From: Carol Reynolds
Sent: 06 February 2017 13:55
To: Planning.Responses
Subject: FW: Planning Consultation on LU/358/16/DOC

APPLICATION LU/358/16/DOC
NO:

Registered: 23-DEC-16
Site Address: Land north of 52 - 67 Greenfields Littlehampton BN17 7HF

Description of Works: Application for approval of matters reserved by condition imposed under LU/223/14/PL relating to condition No. 3 (schedule of materials & samples), 4 (details of screen walls & fences), 5 (Surface water drainage), 6 (Landscaping), 7 (Root

PROPOSED Acoustic Fencing

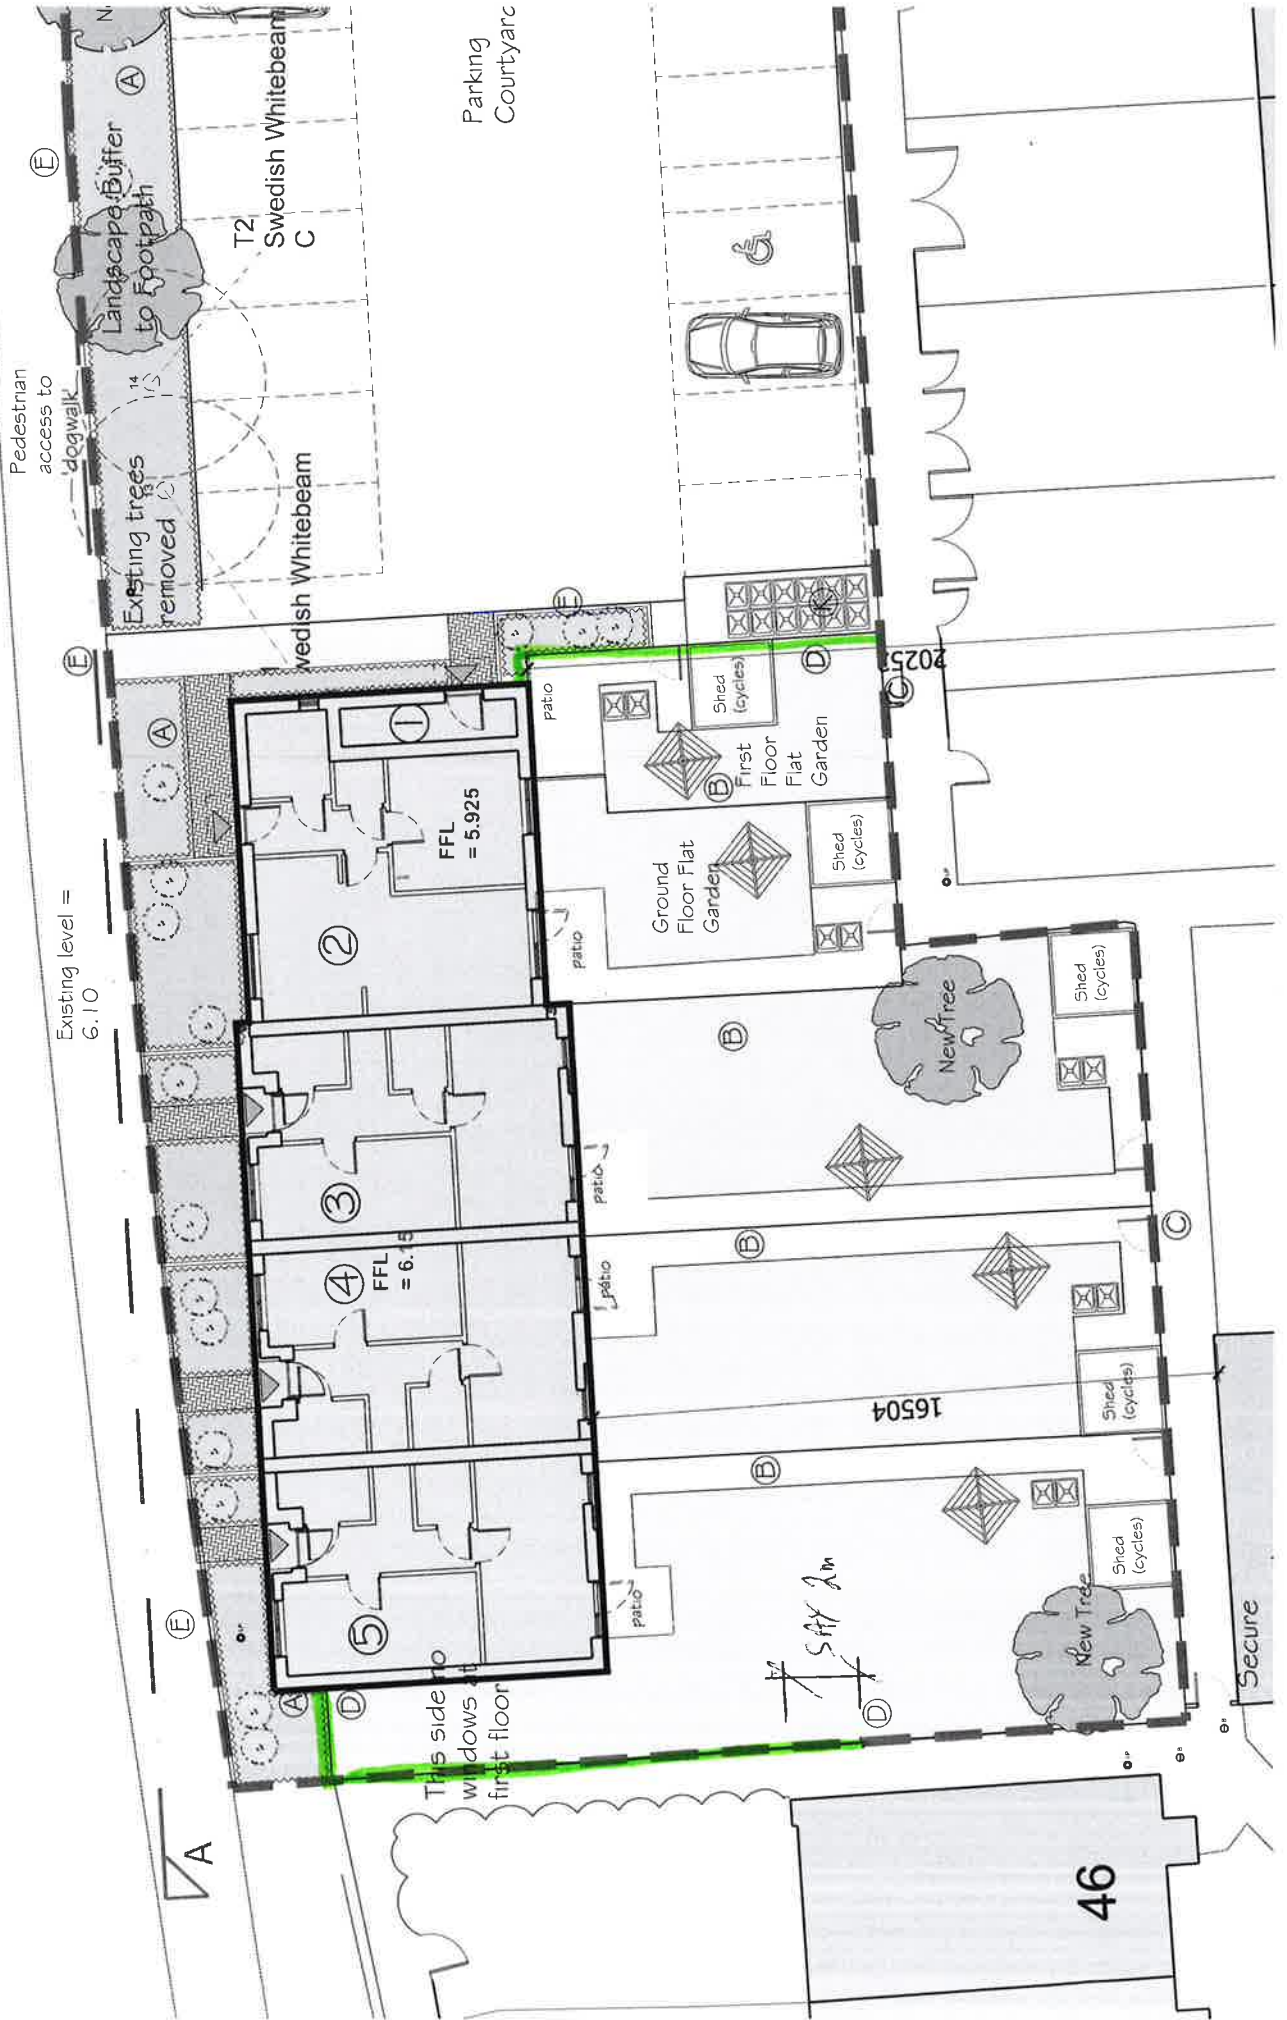
Condition 4: Acoustic Screening to External Amenity Space.

The World Health Organisation identifies that a sound pressure level in gardens, etc., of greater than 55dBLAeq is likely to give rise to serious annoyance. The Environmental Noise Assessment prepared by Ian Sharland Ltd. Noise & Vibration Specialists 29 April 2014 in respect of infill of residential units in the combined Greenfields and Joyce Close (para 5.11 -14) indicates that daytime noise levels to the majority of garden areas lie within with in the unsatisfactory 55-60dB(A) noise level. The Acoustic Barrier provision as detailed in the applicant's report does not accord with the specification requested in the above Environmental Noise Assessment. Please provide suitable proof that this alternative will provide at least the same attenuation as the design brief. Until this information is received then I unfortunately cannot agree to discharge of this Condition.
